Project: EN10147

Request for Access to Soil Sampling Plan Referenced in Blenheim's Submission

PVDP detailed as Community Food Growing Areas

RR: 20051450
22 July 2025

**Illustrative Masterplan**  
**Figure 2.2A**  
 Central Site Area 1 of 4

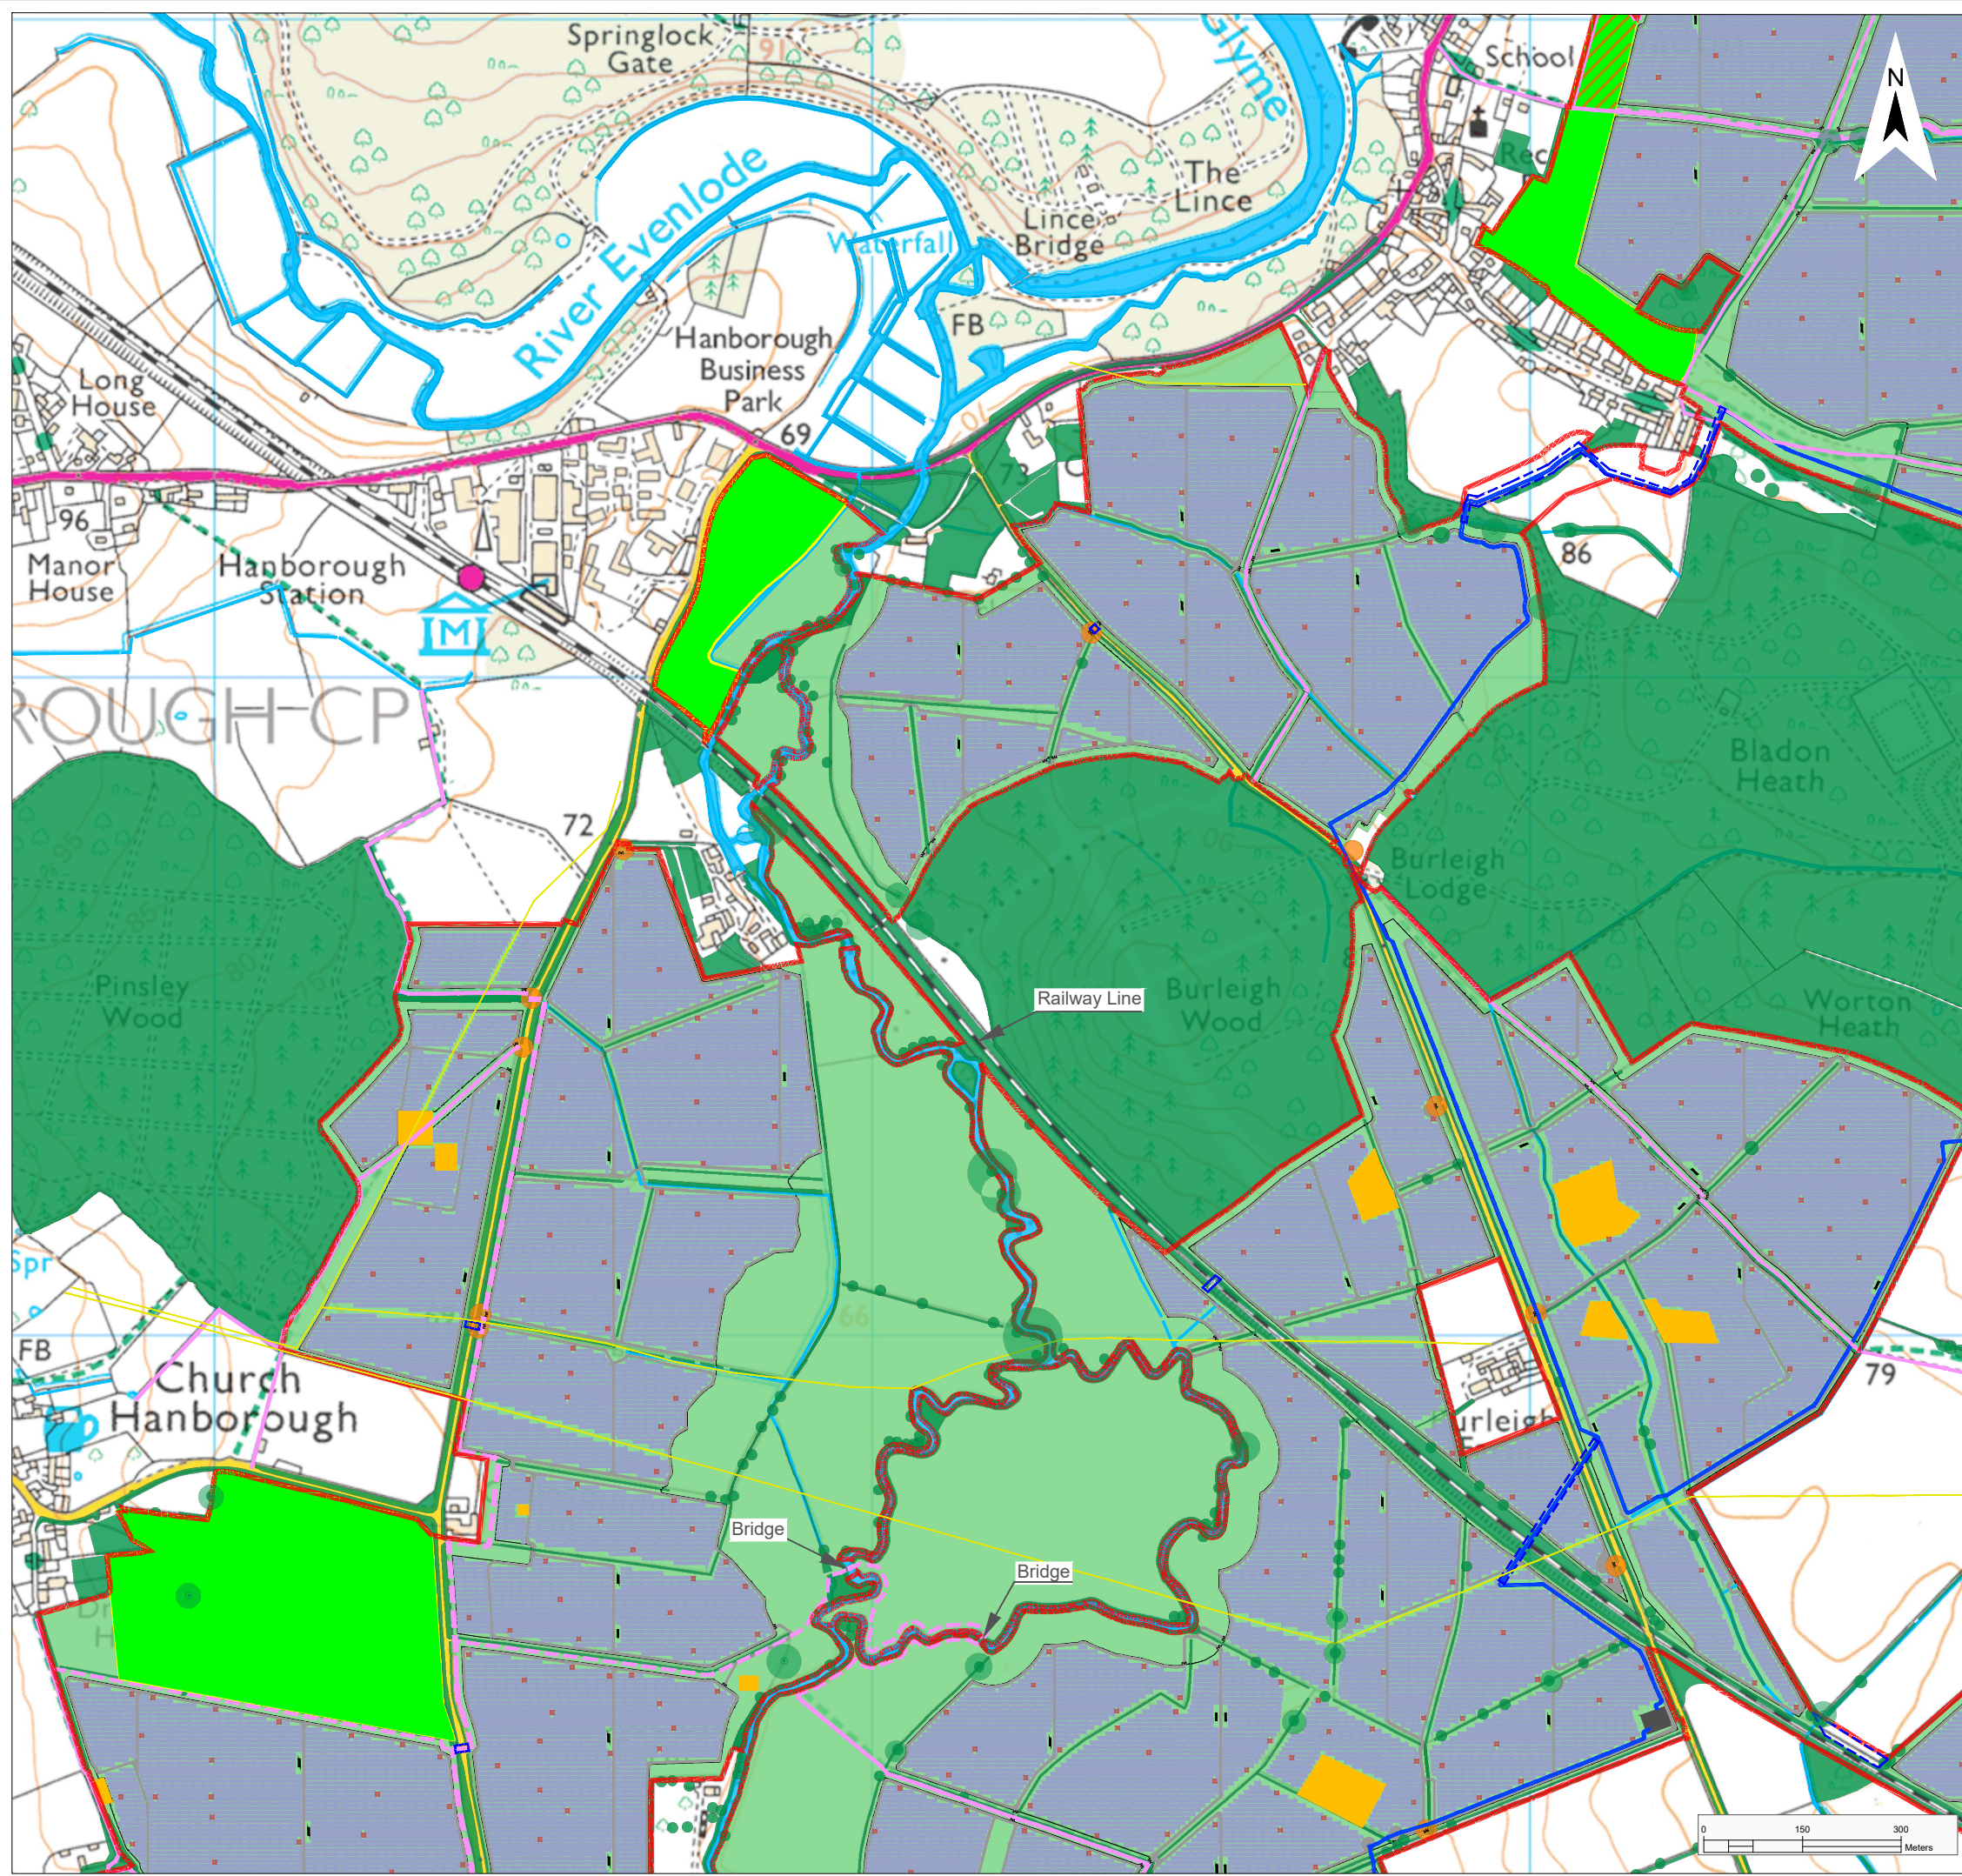
One of the Community Food Growing areas is in Hanborough Parish which is in a Conservation Area. (Field No 2.116 11.96Ha)
(App-131 Appendix 7.1 Historic Environment desk based assessment Figures 2a-c)

(marked bright green on map and the Key indicates that this field (2.116) is for Community Food Growing and also for an area of “new planting for enhancement”)!)

Field 2.116 lies within a designated Conservation Area so that:

- Any proposed development must **preserve or enhance** the area's character.
- Compulsory purchase would require **robust justification**, especially under the Planning (Listed Buildings and Conservation Areas) Act 1990.

Land Plan Reference 8-28 is field 2.116 (124,161m²) and it would appear to be subject to a Compulsory Purchase Order BWSF Land Plan Reference 8-28 (i.e. field 2.116).

1. Why does this field have to be Compulsorily purchased?
2. What say will CHC have in its ownership and organisation?
3. What will be the benefit to CHC?
4. The operators of enterprises in this Conservation Area must be made aware that they will need to obtain planning permission to erect buildings in which to store equipment, packaging and produce.
